Markup Summary

DATE:
 MARCH 1, 2018
 PROJECT NO.
 100.042
 SHEET NUMBER
 C5.2
 TOTAL SHEETS: 44

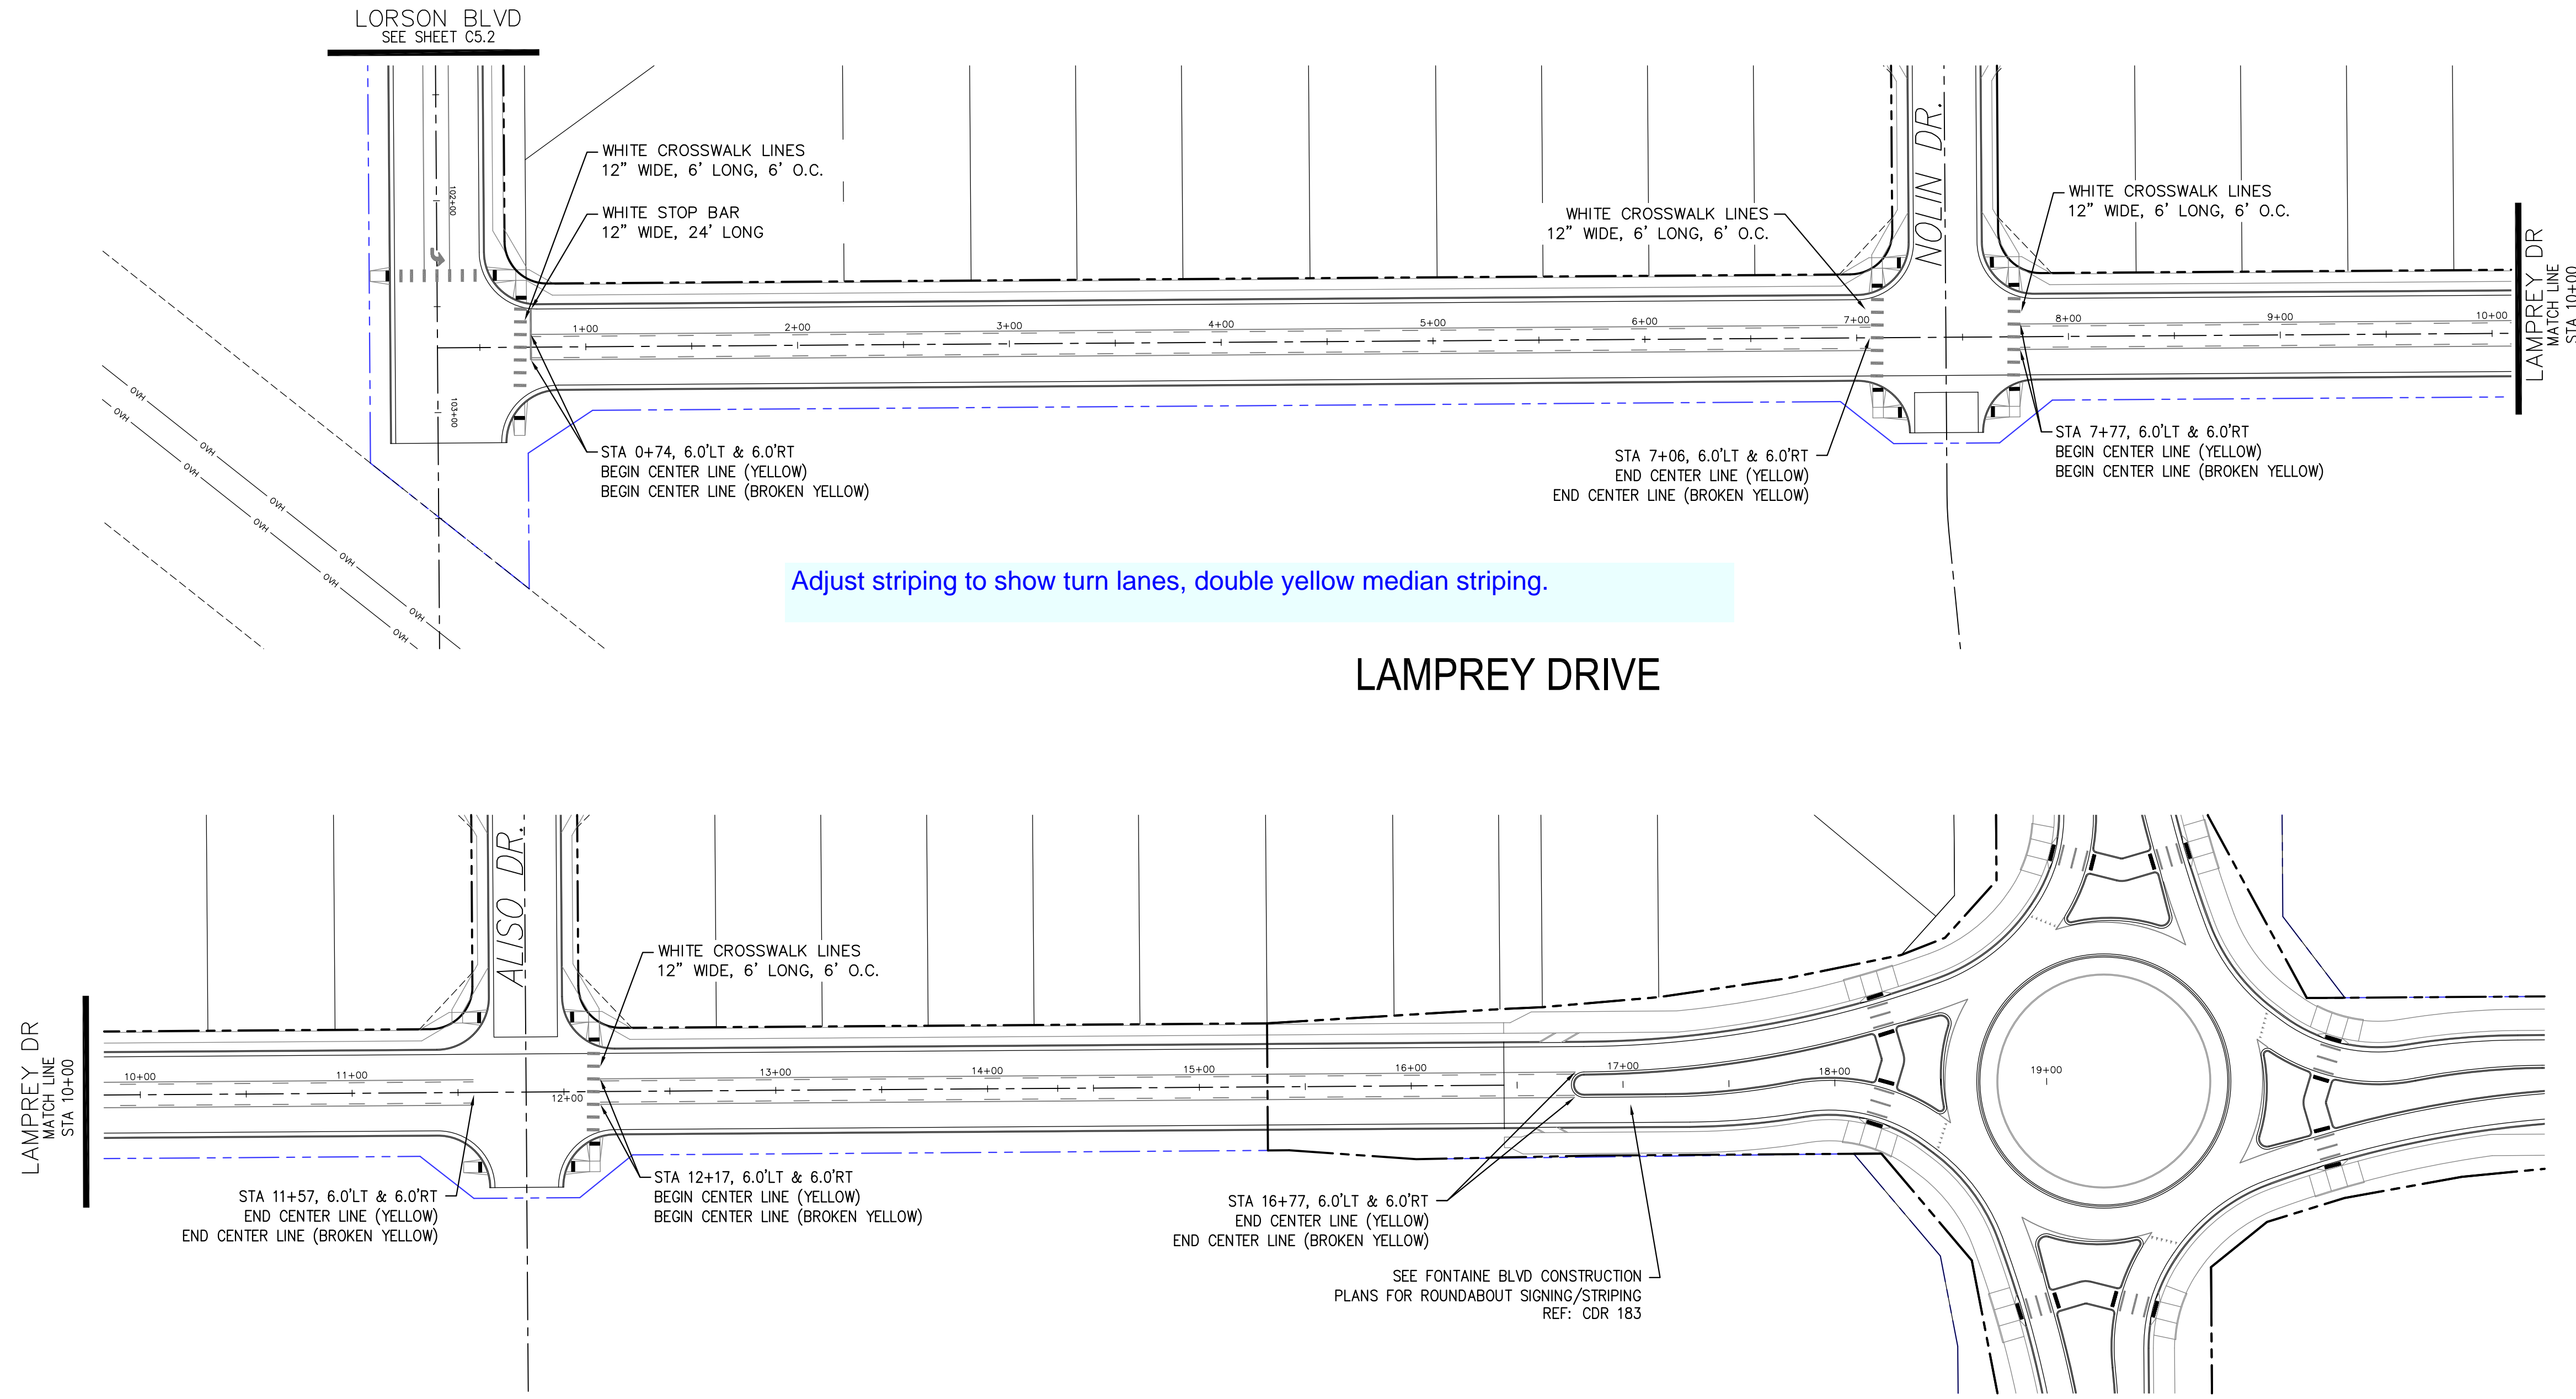
Show turn lane, double yellow median
